Subject: P/118/26/L

Little Welbourne Church Lane Pagham PO21 4NX

Listed building consent for the replacement of double glazed aluminium / timber windows and doors with double glazed painted timber casement, sprung sash windows and matching French doors.

DRAWING TITLE
Proposed Window / Door Schedule

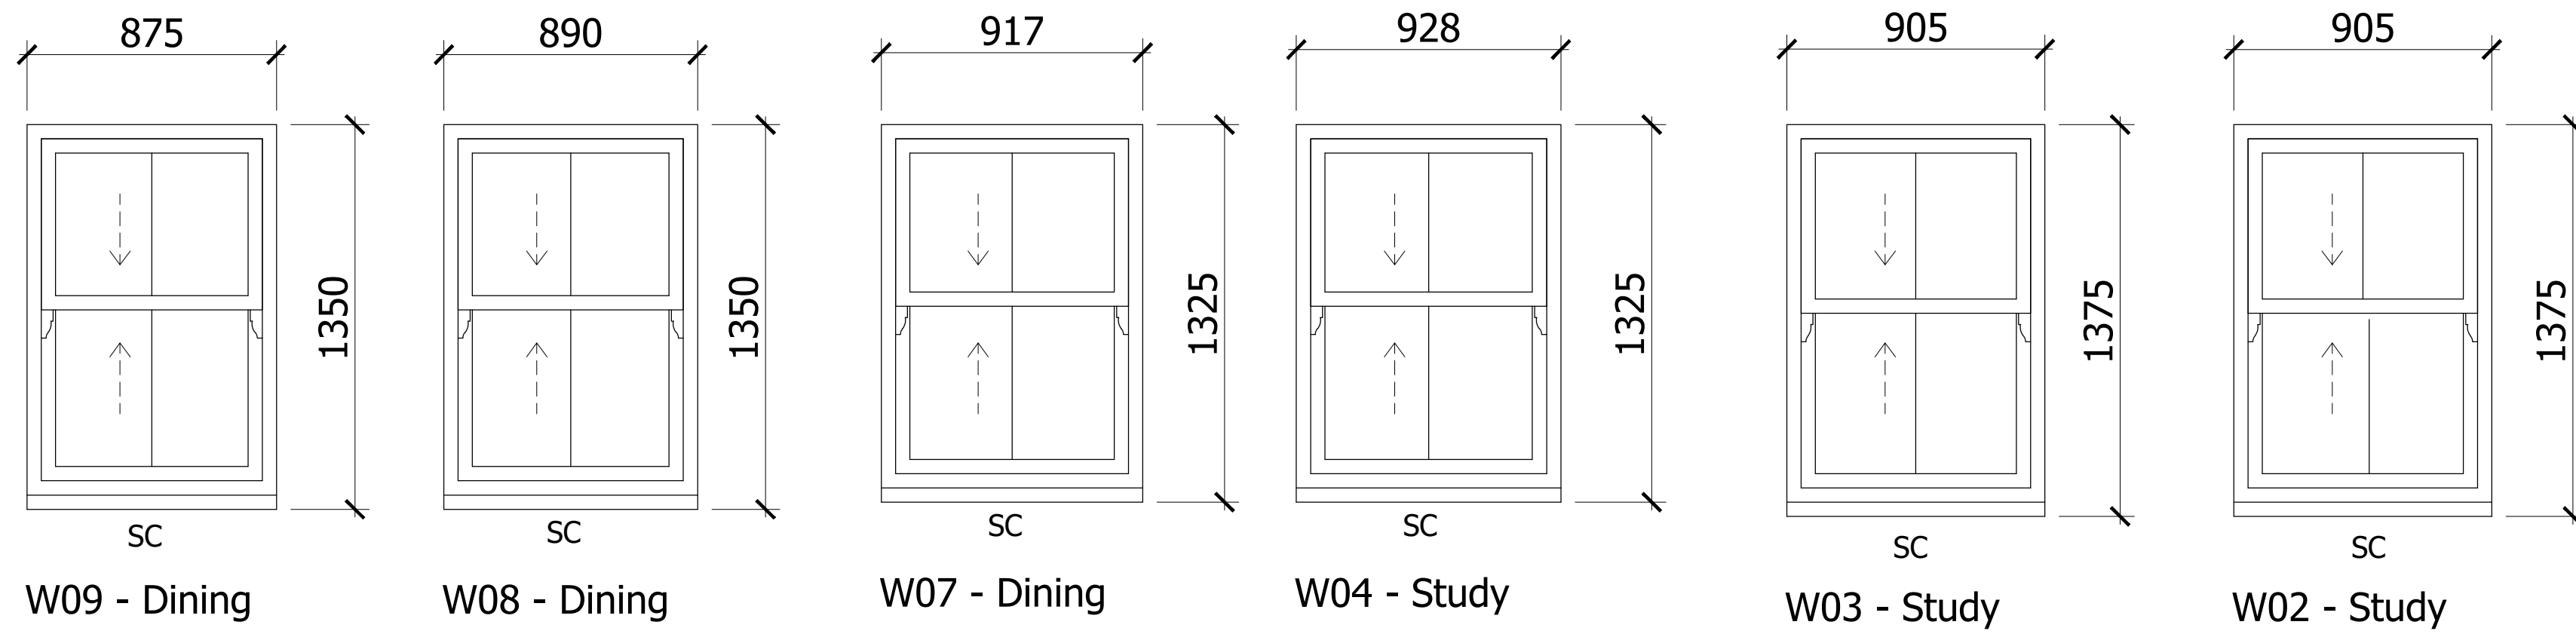
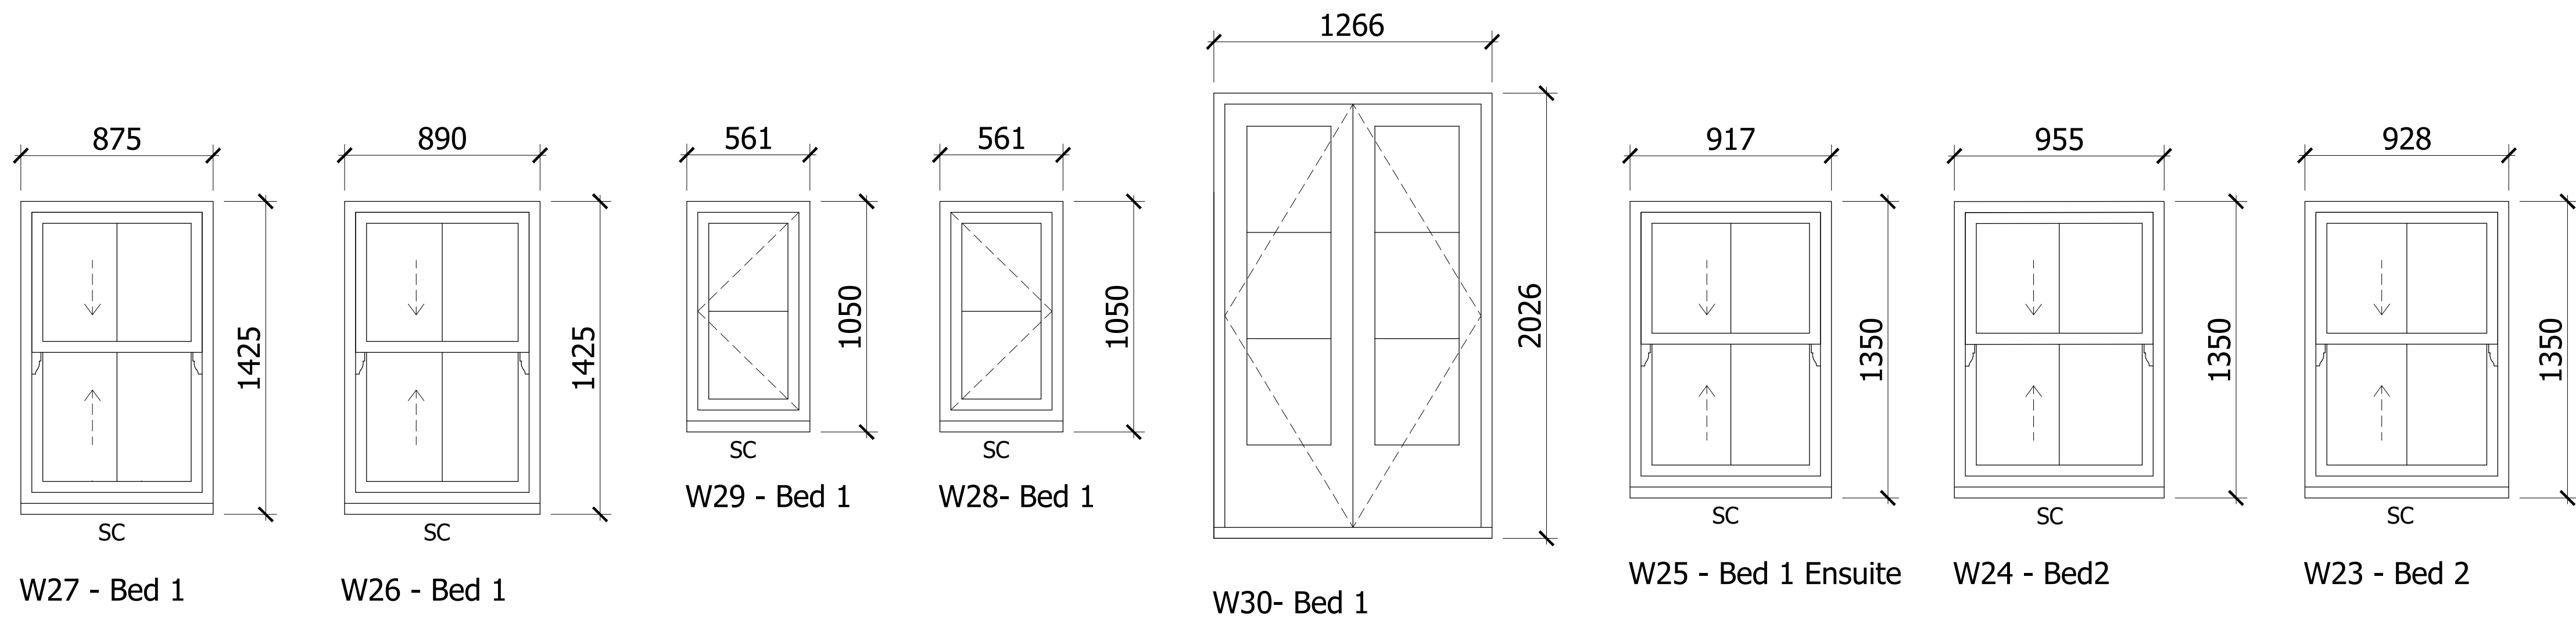
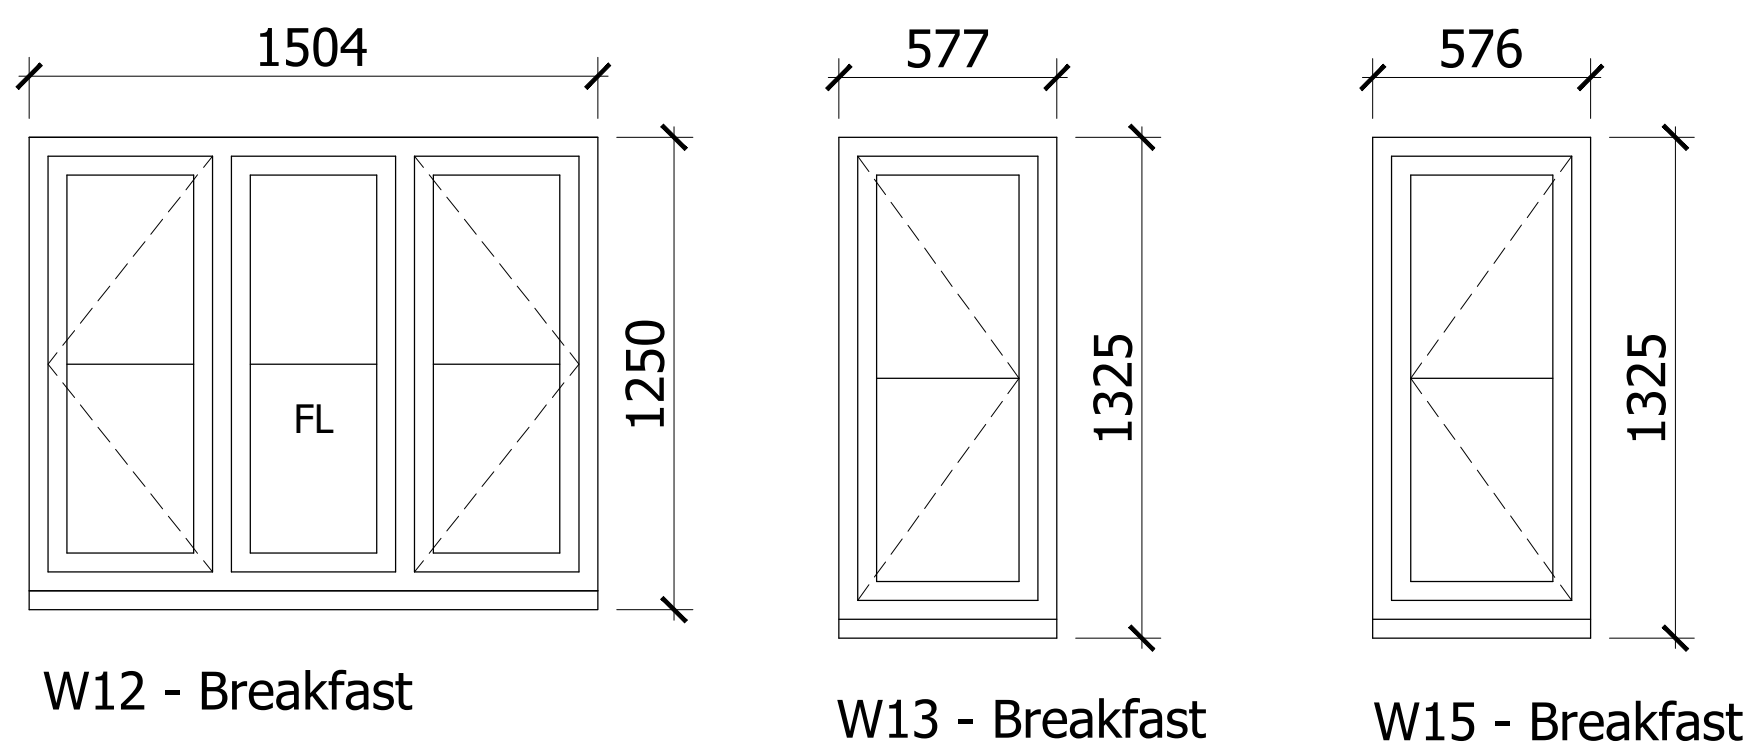
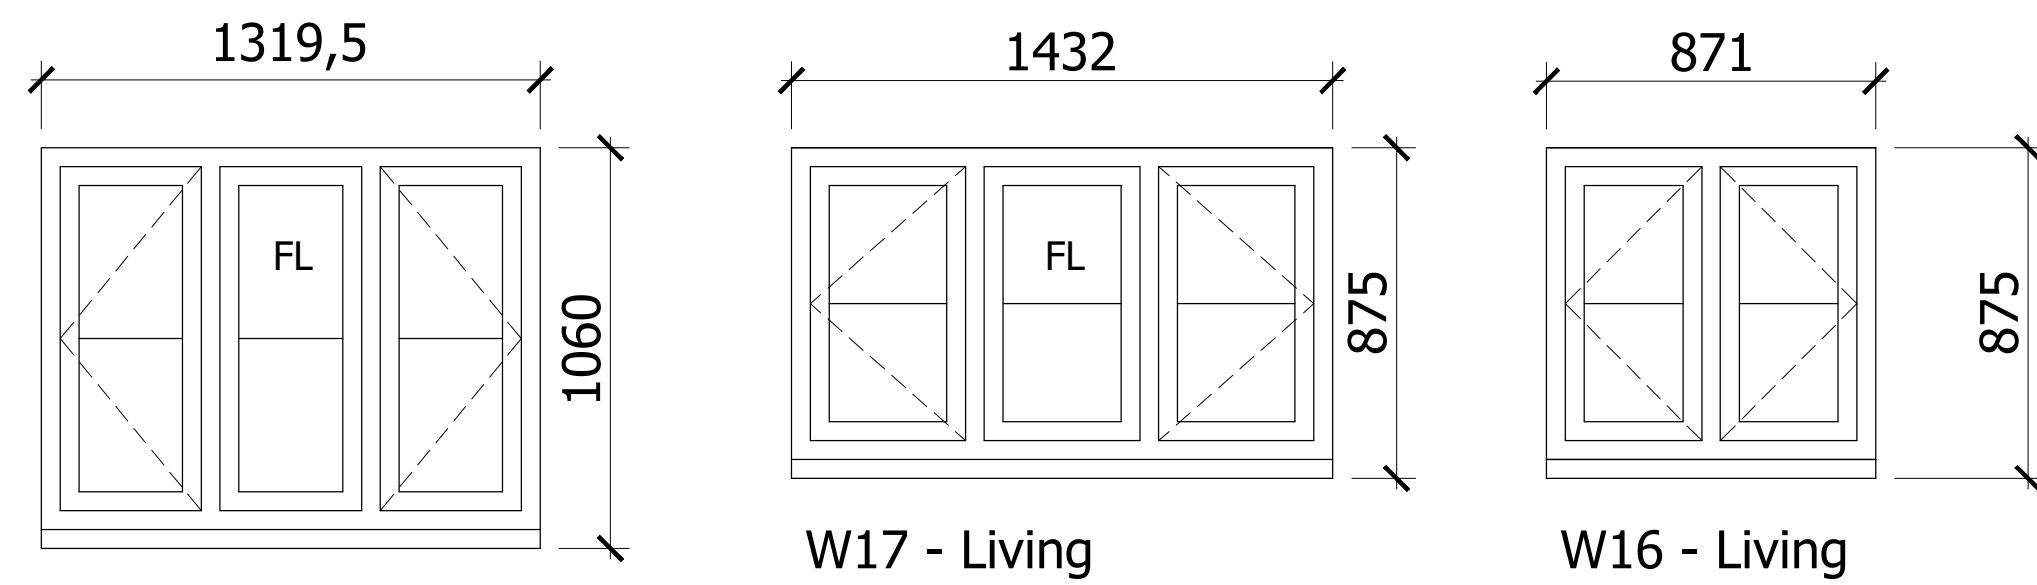
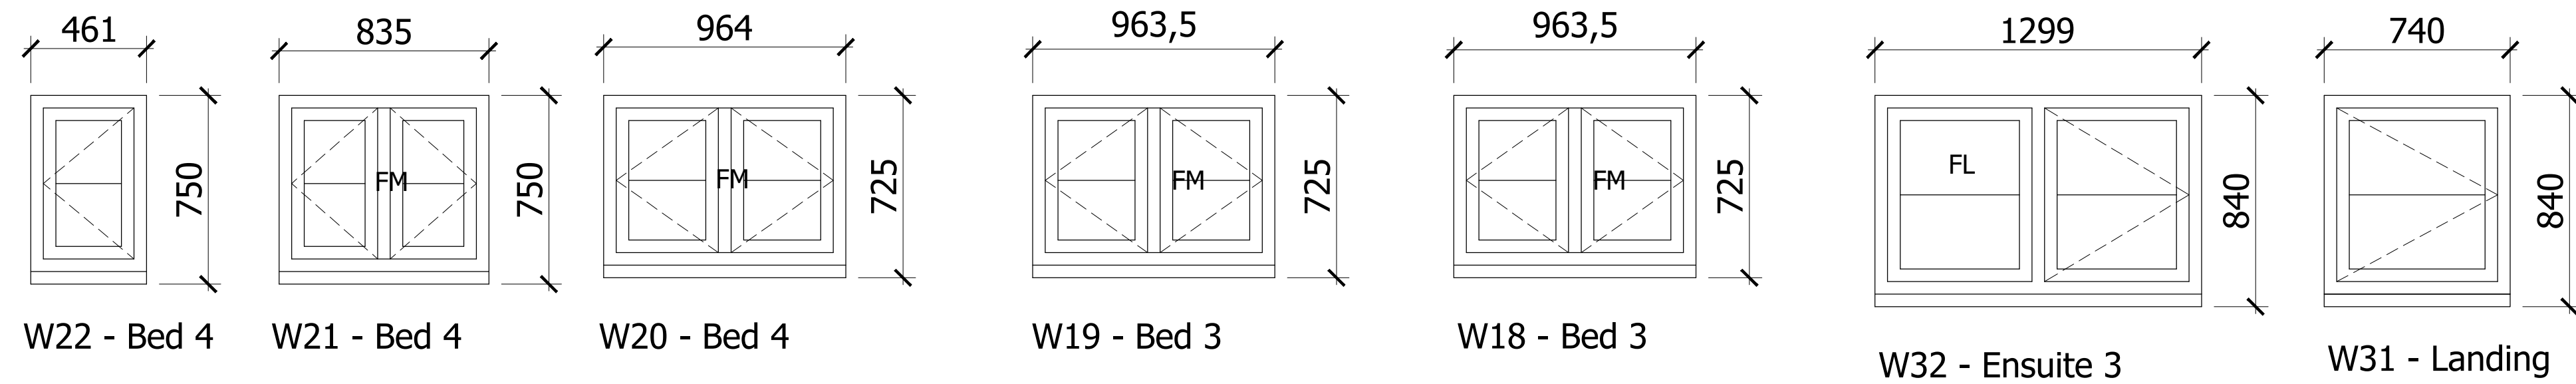
The submitted joinery details indicate that the glazing bars will form part of the structural composition of the windows rather than being applied to the surface of the glass, helping to achieve a more authentic historic appearance. Furthermore, the slim-profile heritage double-glazed units appear capable of being accommodated within traditionally proportioned timber sections without resulting in excessively bulky frames or glazing bars.

Overall, I am of the opinion that the design of the window and the use of the heritage double glazing is acceptable in this instance
